Our Reference: DOC19/911382

Stockton Quarry - Modification - 3 Stockton Sand Quarry (DA140-6-2005-Mod-3)

NPWS response and detailed comments

Figure 1  
**SECTION LOCATIONS**  
Stockton Sand Quarry Dredging

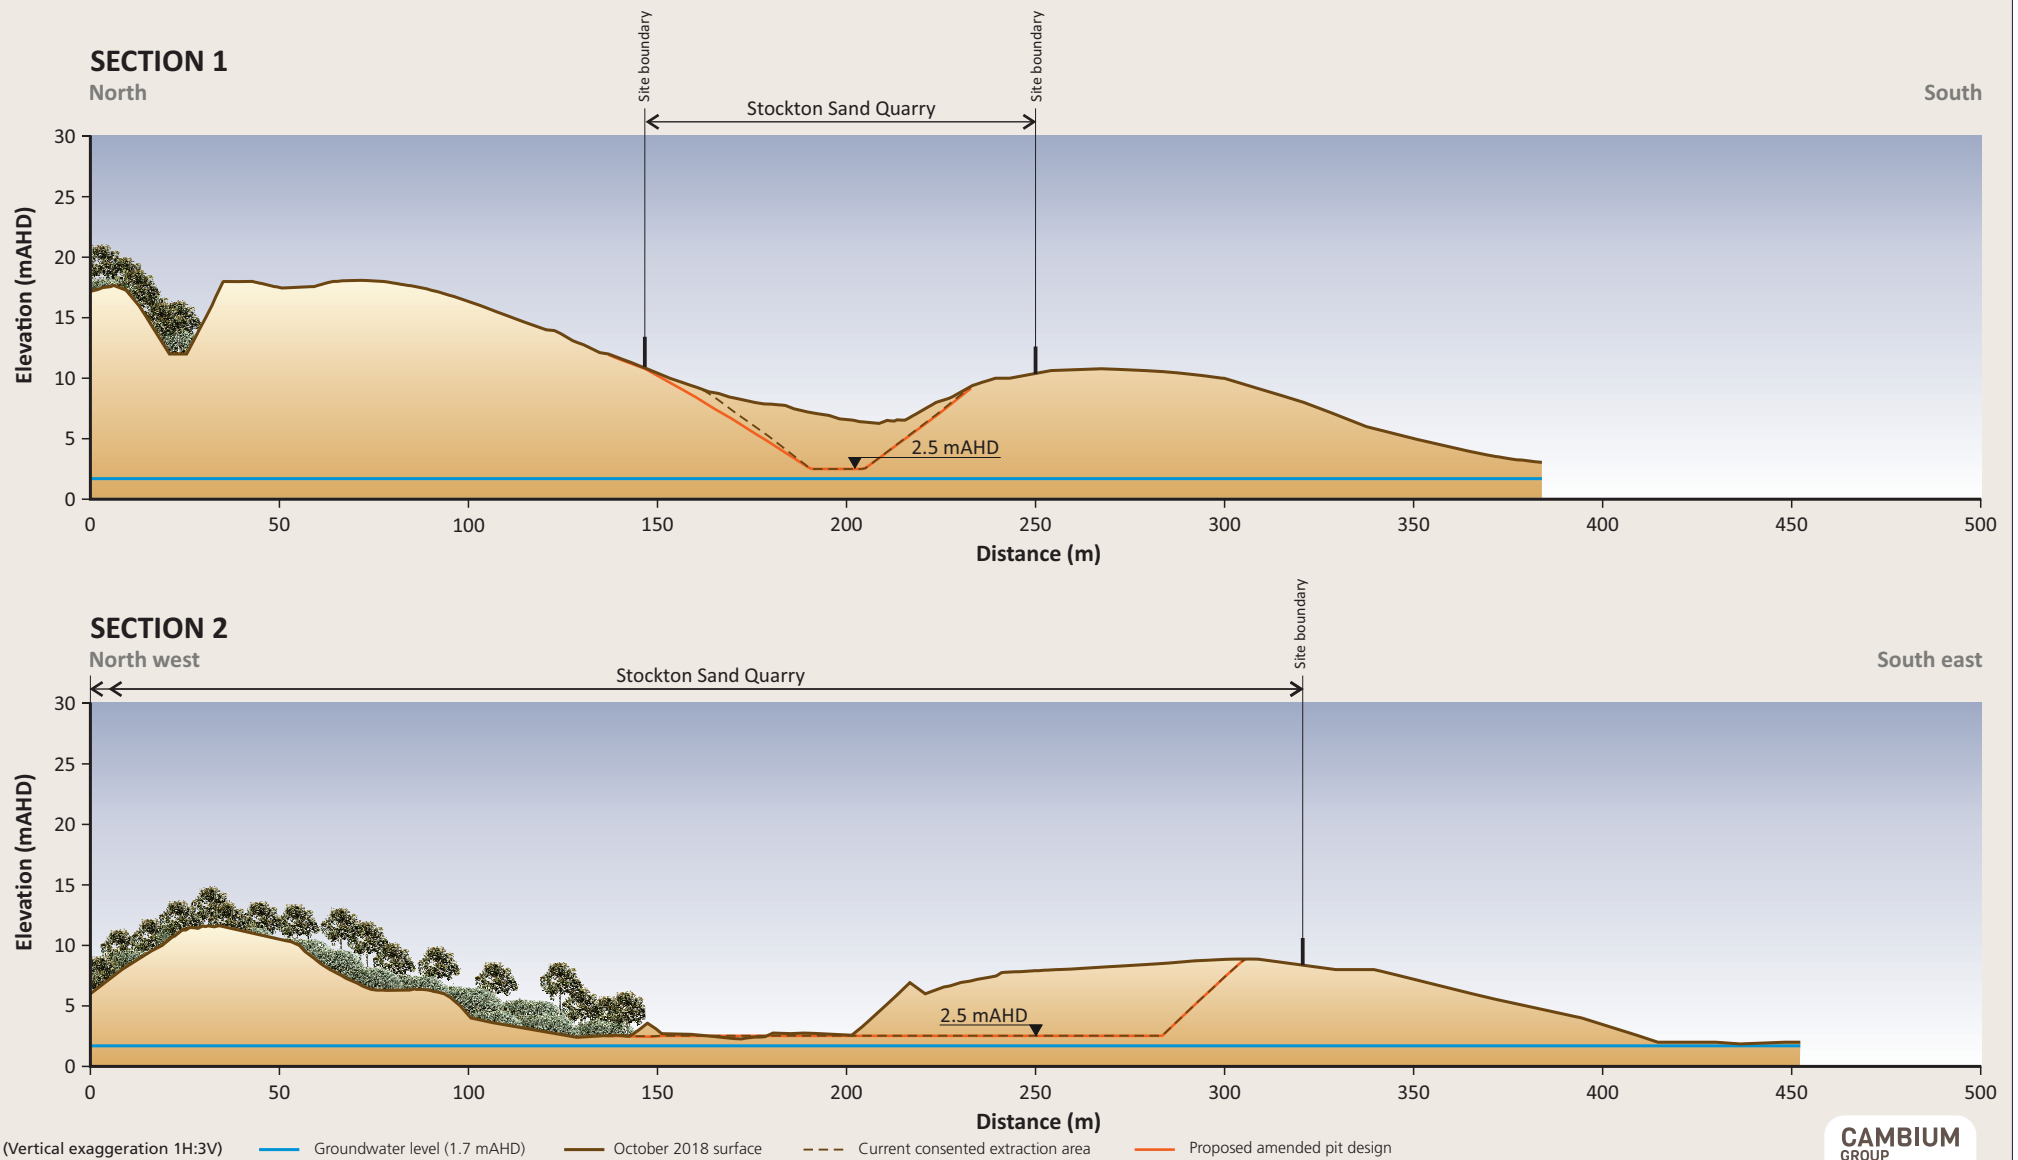
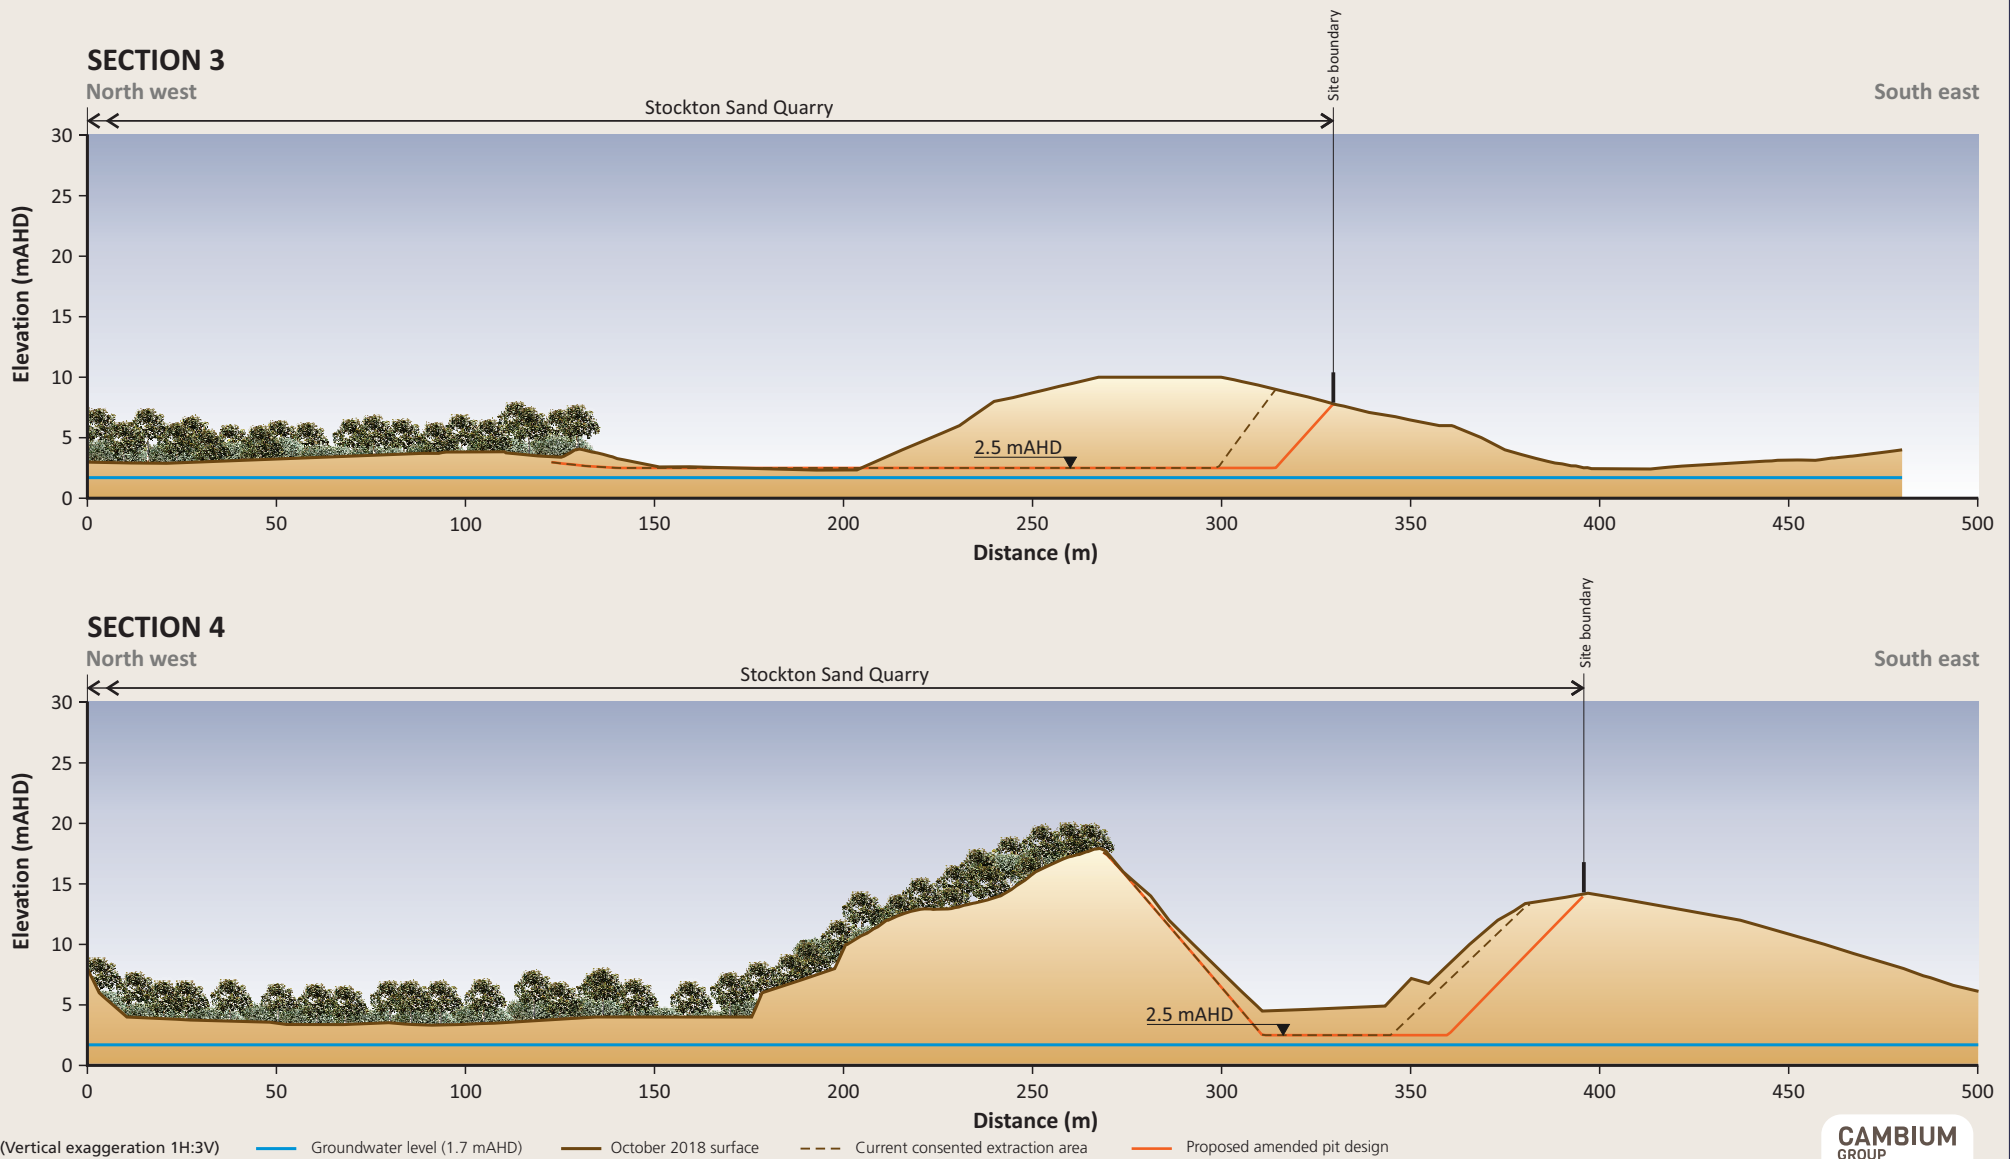
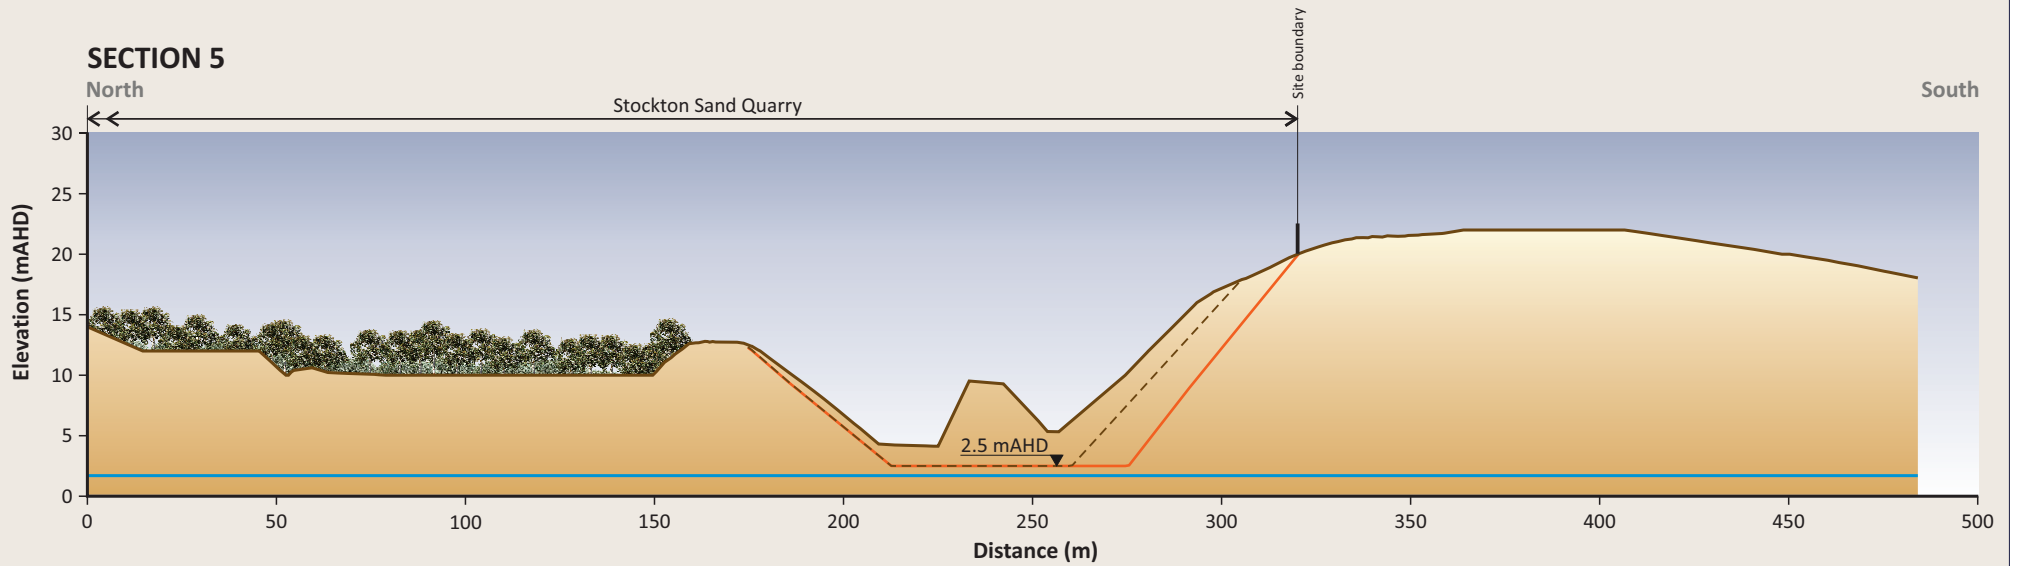
The existing requirement to ensure the footprint of the quarry extraction activity does not go beyond the 15 metre buffer from the boundary is a critical condition of consent that mitigates risk of direct impact on the WCL. The proposed sand extraction extension seeks to remove this and poses a direct threat of impact to the WCL.

The proposed sand extraction extension would have the top edge of the quarry batter slope positioned directly at the boundary of the WCL. This leaves no margin for error to avoid impacts on the WCL side of the boundary. It has been acknowledged in the SEE and RtS that the 15 metre buffer performs the function of ensuring that extraction activity does not directly destabilise and effect the neighbouring land within the WCL. Sand quarried from within the 15 metre buffer area will cause the immediately adjacent dune to actively collapse into the extraction pit, further exacerbating dune deflation on the WCL.

If the buffer area is removed and only the landward batter slope in the quarry is re-vegetated, this will have no impact on stabilising the remaining dune that adjoins the WCL. In these circumstances, the proposed sand extraction extension would result in an increased extent and rate of deflation in the WCL, lowering the dune further.
